RE: Sieber Short Plat (SP-06-93)

The Kittitas County Community Development Services Department has determined that the Sieber Short Plat is a complete application and hereby grants **conditional** preliminary approval subject to the following conditions:

TO: Noah Goodrich, Community Development Services
FROM: Christina Wollman, Planner II *CW*
DATE: December 20, 2006
SUBJECT: Sieber Short Plat

# SIEBER SHORT PLAT

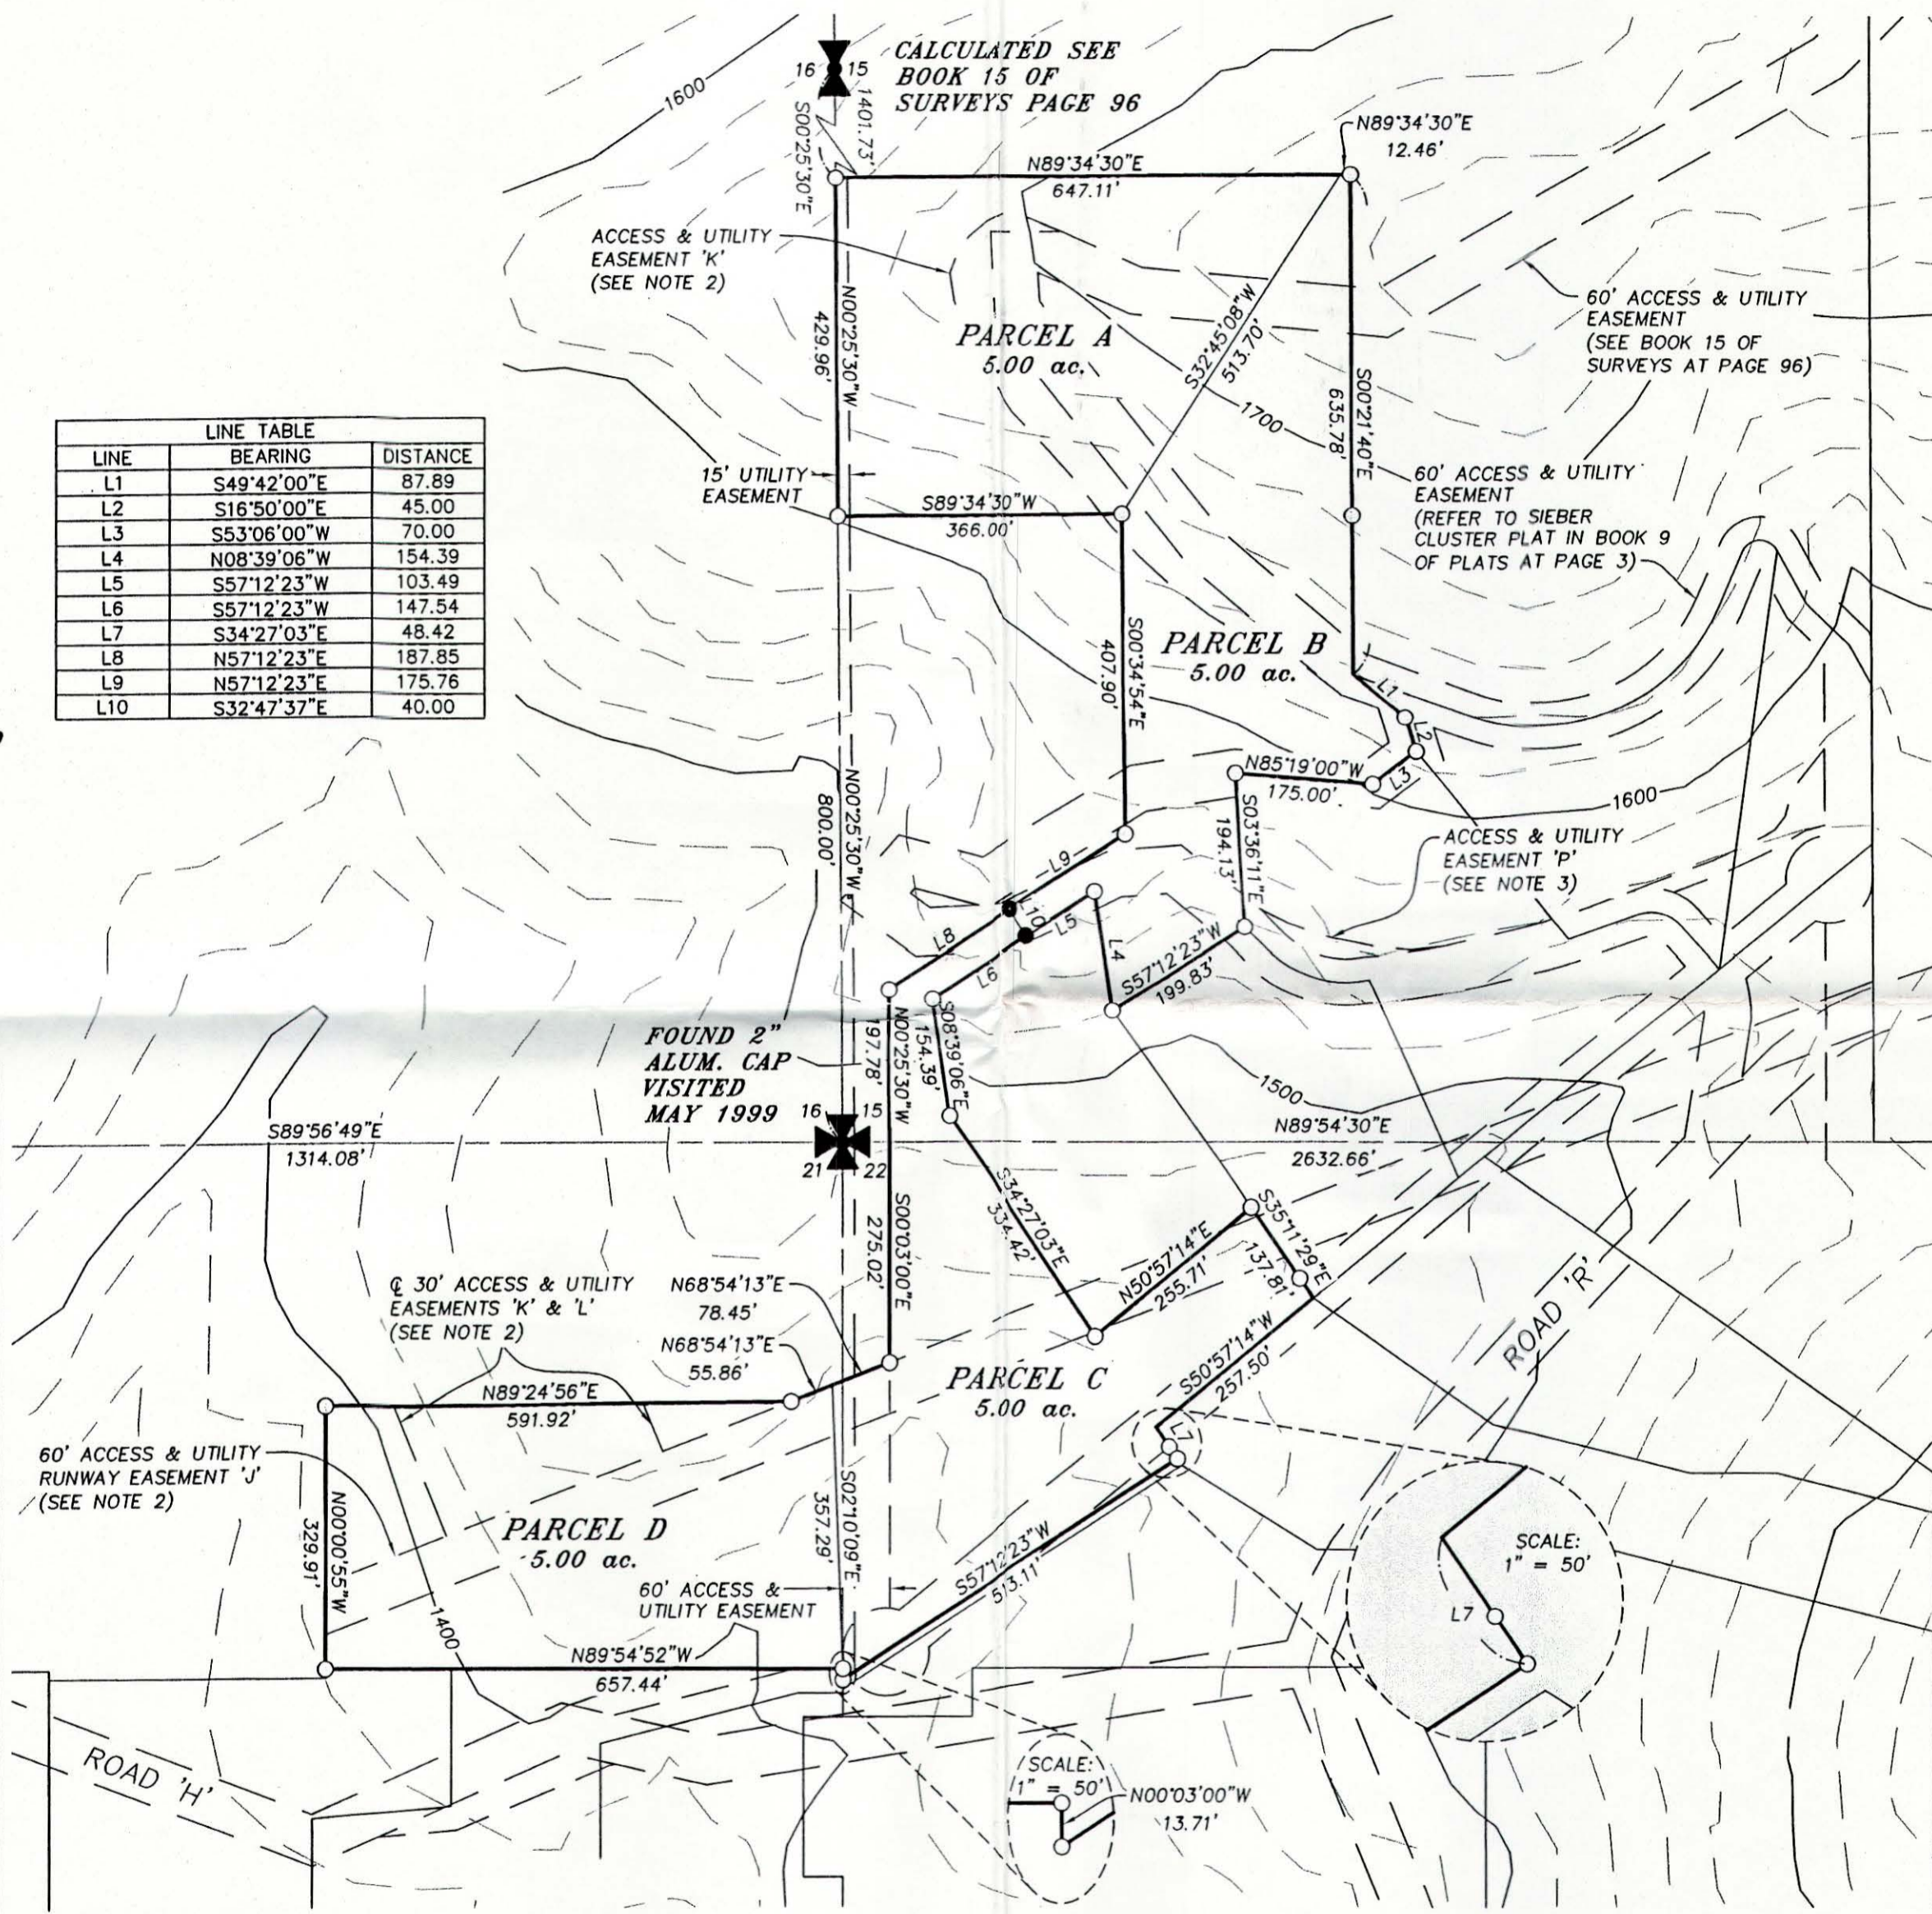
1. Both sheets shall reflect the short plat number SP-06-93.
2. All future development must comply with International Fire Code (IFC) and appendices.
3. The subject property has an existing approved approach permit from the Washington State DOT. No additional approaches will be allowed. Please see the attached DOT comments.

- a. The width of Easement 'P' shall be shown on the face of the plat.
 - b. Easement 'P' appears to serve three or more lots. Roads serving three or more lots are required to be built to the minimum standards of a high-density private road. These standards are shown above in condition #2.

- c. Easement 'P' is has a paved roadway width of approximately 15'. The roadway width for a private road serving three or more lots is 20' with 1' shoulders for a total width of 22'. Easement 'P' shall be widened to meet the minimum design standards required for this road type.

- c. Any further subdivision or lots to be served by proposed access may result in further access requirements.
- 6. Plat Notes: Plat notes shall reflect the following:
 - a. Remove the reference to KCC Section 12.05 from plat note #9. The second sentence of the note shall read: See Kittitas County Road Standards.
- 7. Mailbox Placement: Mailboxes must be approved by U.S. Postal Service. Mailbox locations are site specific. The U.S. Postal Service requires that private roads with 6 or more residences install USPS approved Cluster Box Units (CBUs) at a safe location at the mouth of the private road. Contact your local Post Office for location and design standards before beginning construction.
- 8. Plat Approvals: All plats must show the acceptance signature of the County Engineer. The acceptance block shall be as follows (per KCC 16.24.170):
